Application No: K/52/20/HH
Site Address: Flint Barn Peak Lane Kingston Gorse BN16 1RN
Description of works: Single storey front extension, first floor front/side extension, first floor rear extension and conversion of roofspace to habitable use to include a juliette balcony.

Thank you for your internet representation made on 12th January 2021 which has been recorded as an objection with the comments as follows:

Client	
Mr K P & Mrs V L Eaton	
Project	
PROPOSED EXTENSION TO FLINT BARN, PEAK LANE, KINGSTON GORSE, WEST SUSSEX, BN16 1RN	
Title	
PROPOSED SECOND FLOOR PLAN	
Drawing Status	
PLANNING APPROVAL	
Drawn	Checked
KPE	
Scale	
1:50 @ A3	
Date	
31 Jan 2020	
Job No	Drawing Number
20/01	2020/Jan/Plan. 003

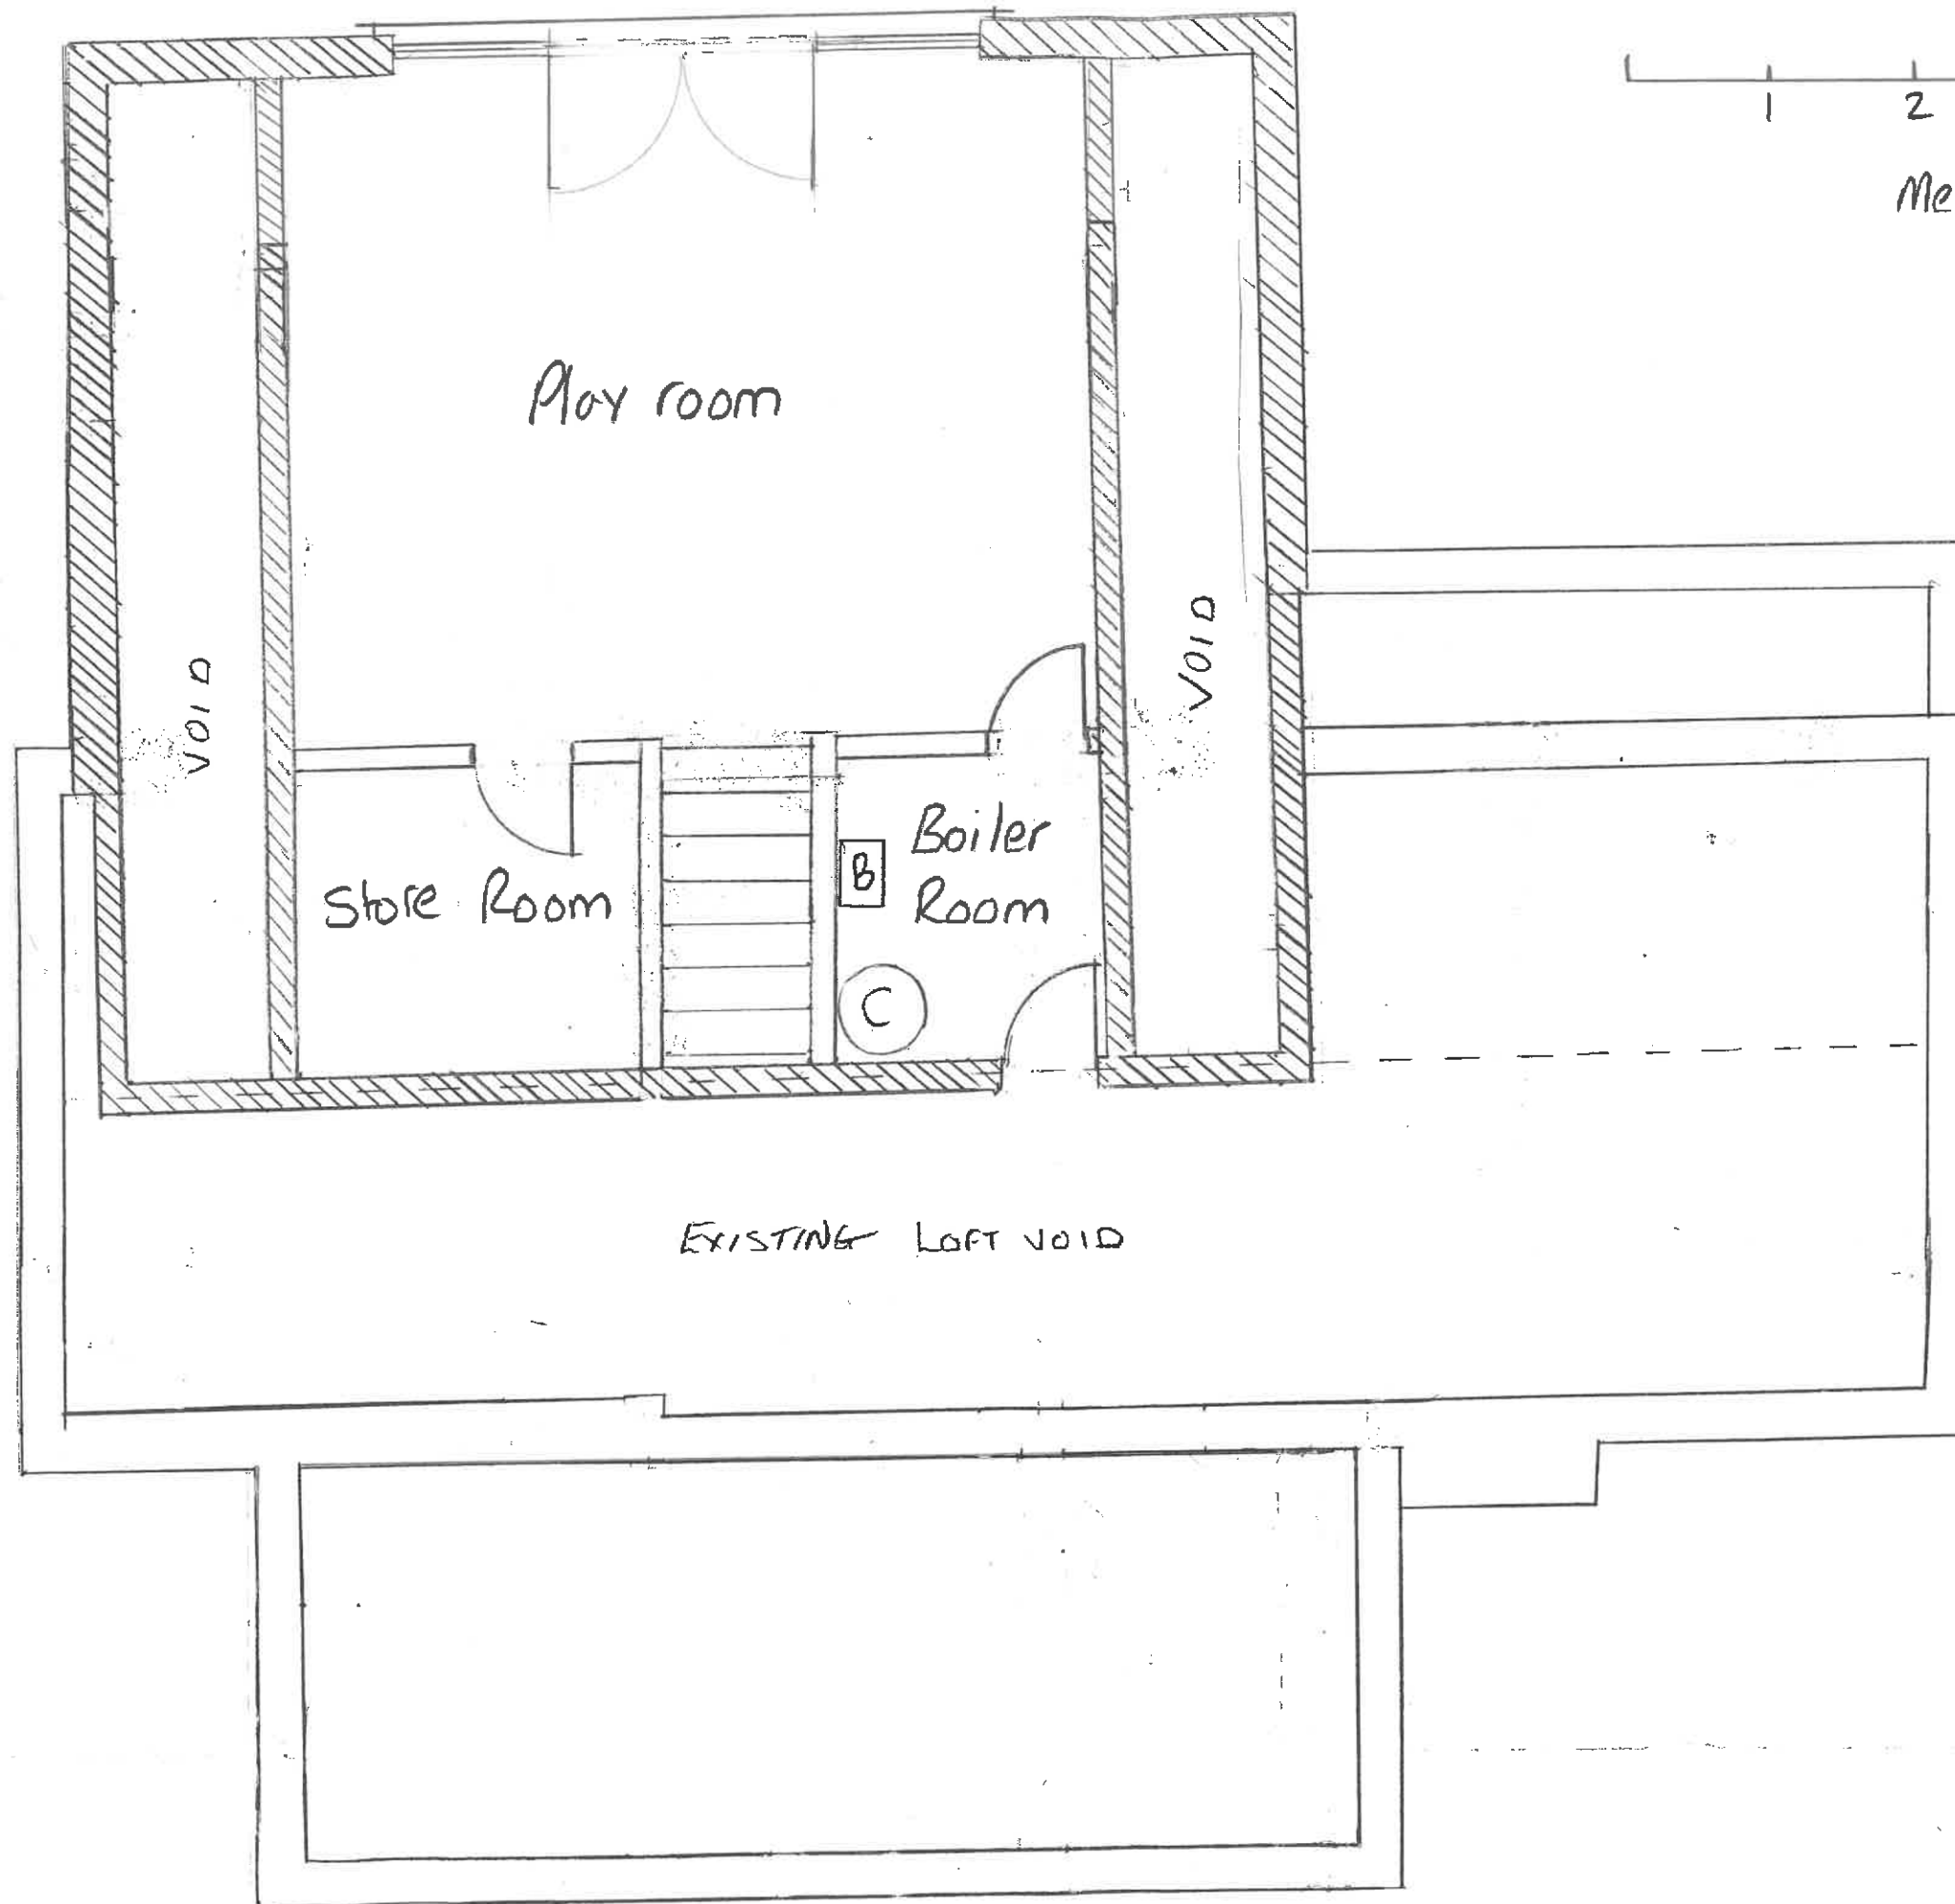
2 floor and roof plans shows one dormer with two sky lights. and does not match the north elevations which shows 2 separate dormers. The block plans shows the drive way marked in red, this is not his property. the drawings are lacking detail and are not correct and in my opinion should not be validated
